BCA CAPABILITY STATEMENT

Building 6
Lots 23 & 24 Hollinsworth Road, Marsden Park,
NSW 2765

Prepared for: Logos Property | Issue date: 23 Nov 17

1 SITEPLAN
1:1000

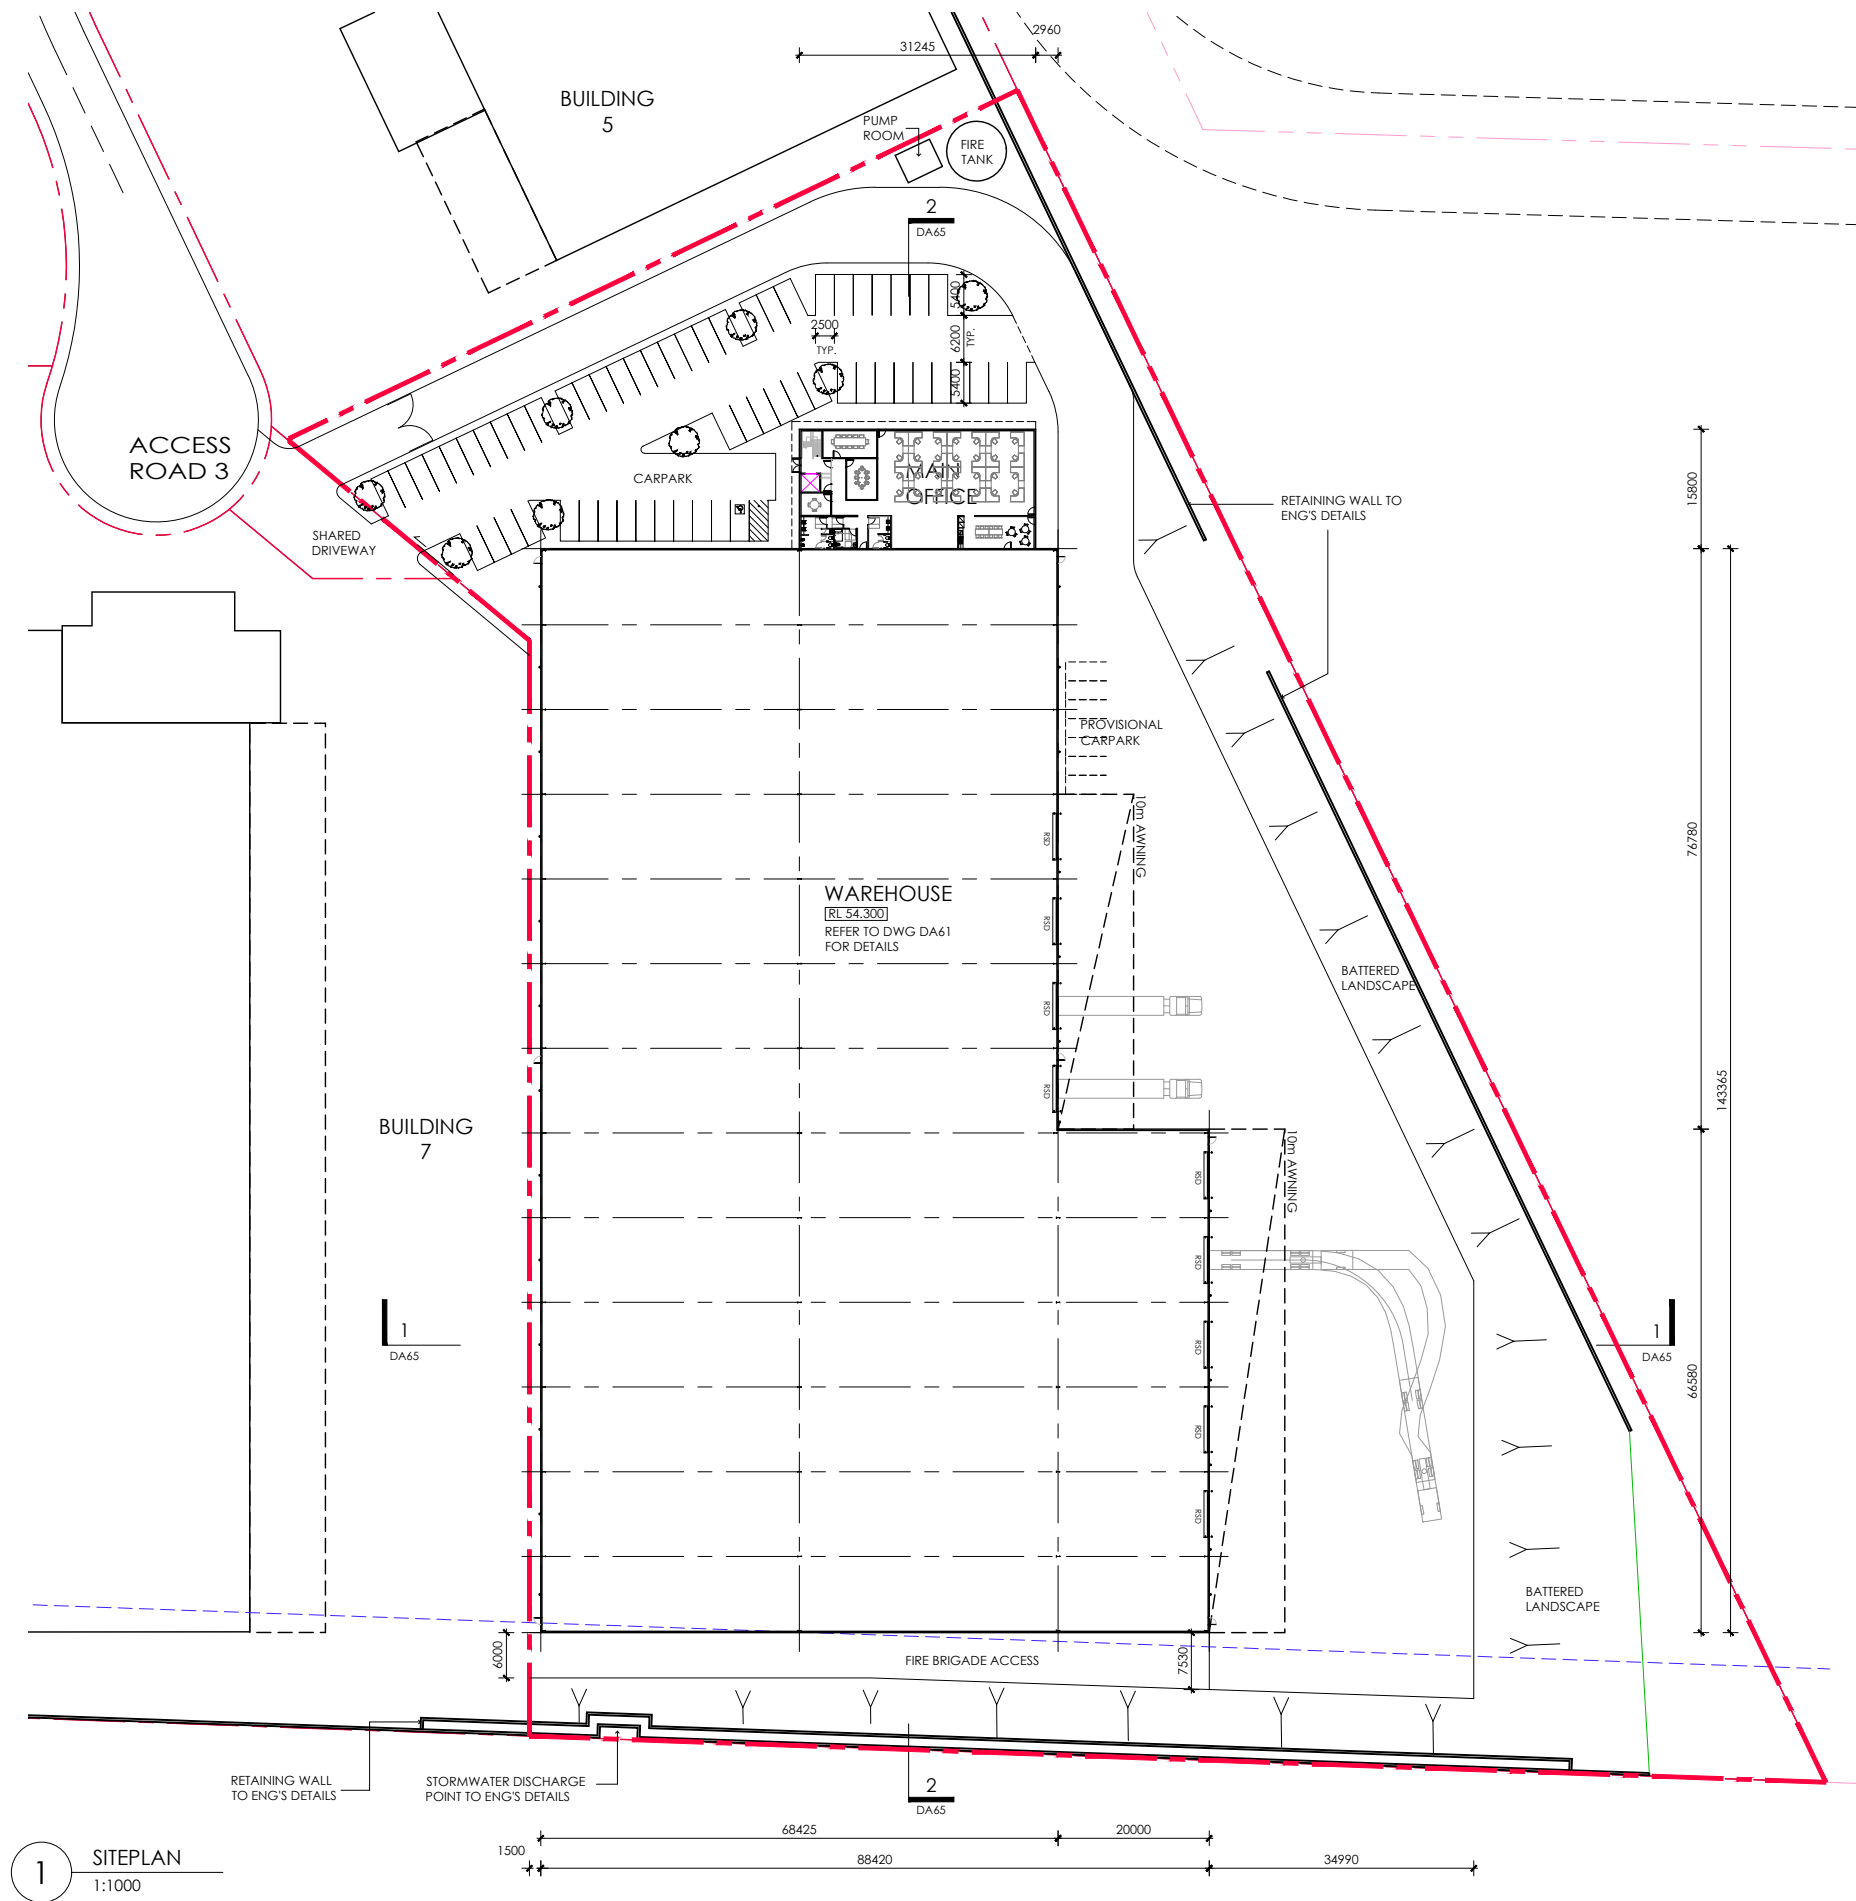
DTS Clause	Description of Non-Compliance	Performance Requirement
C2.4	<u>Requirements for open space and vehicular access</u> - The furthest boundary of vehicular access is greater than 18m from the north, east and western sides of the building with the maximum distance being 42m on the eastern side. - Building 6 & 7 are proposed to use a shared driveway for the purpose of access to the lots and perimeter vehicular access for emergency services. This building is to be accompanied by a reciprocal right of carriage over all shared vehicle paths. - The vehicular access is built upon by security gates	CP9
D1.4	<u>Exit travel distance</u> 80m to an exit in lieu of 40m within the warehouse portion. 41m to a single exit in lieu of 20m. The installation of an additional internal exit stair is required and will be addressed through design development prior to the issuance of a Construction Certificate.	DP4, EP2.2

Drawing Title
BUILDING 6: WAREHOUSE PLAN

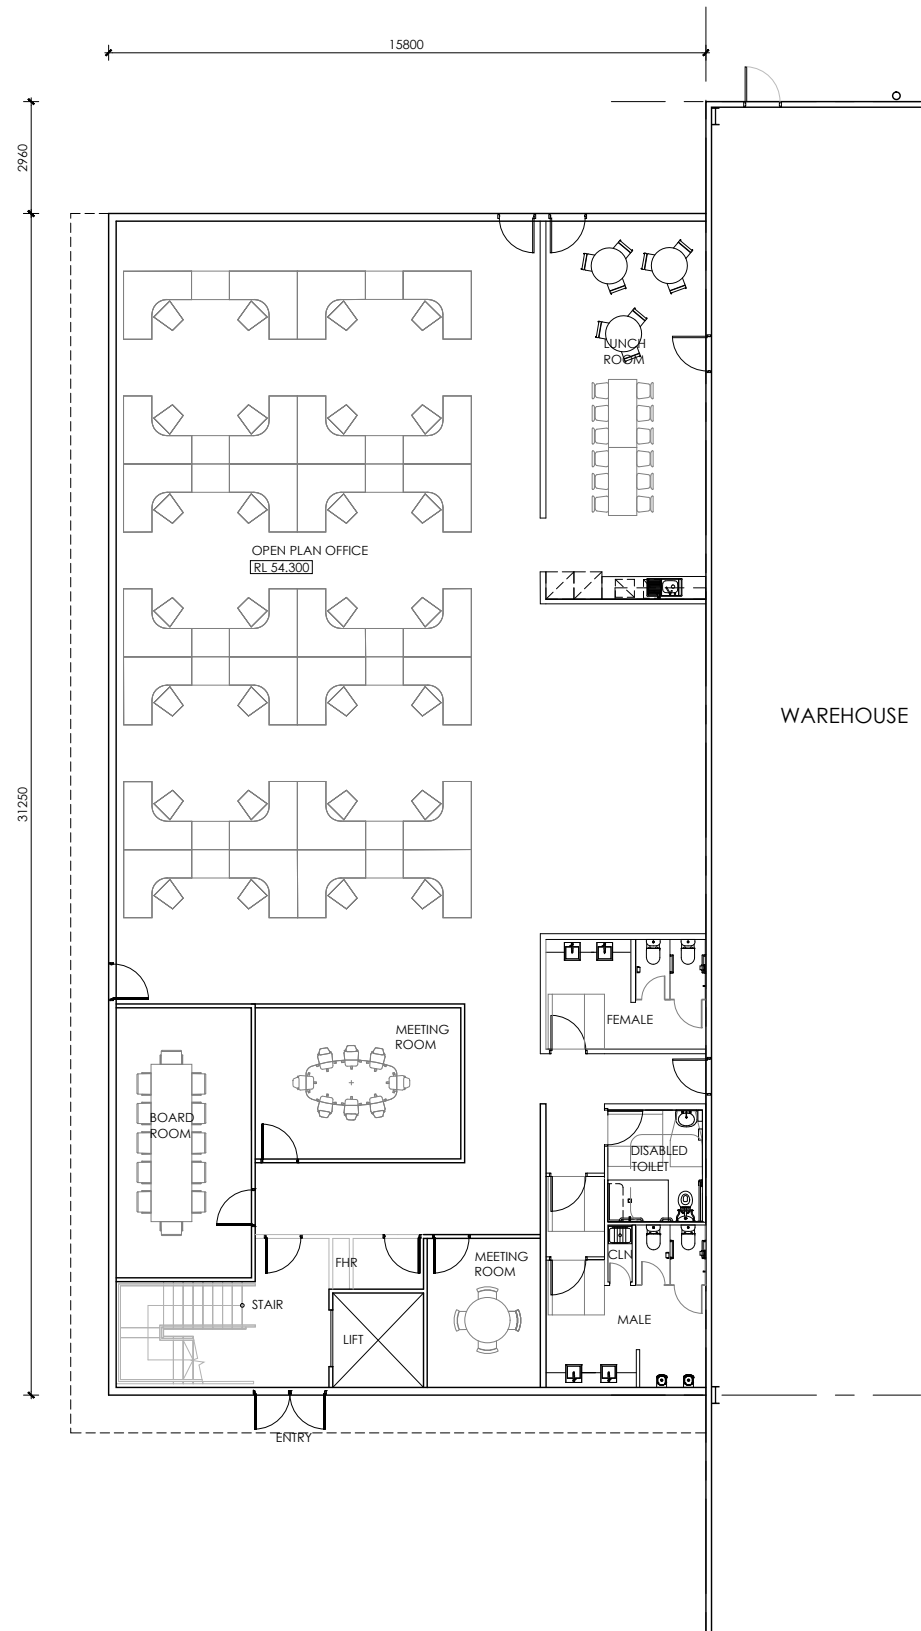
D1.5	<u>Distance between alternative exits</u> 91m between alternative exits in lieu of 60m	DP4, EP2.2
E4.5/ E4.6	<u>Exit and directional signs</u> Exit signs are proposed to be located greater than 2.7m above the floor level.	EP4.2
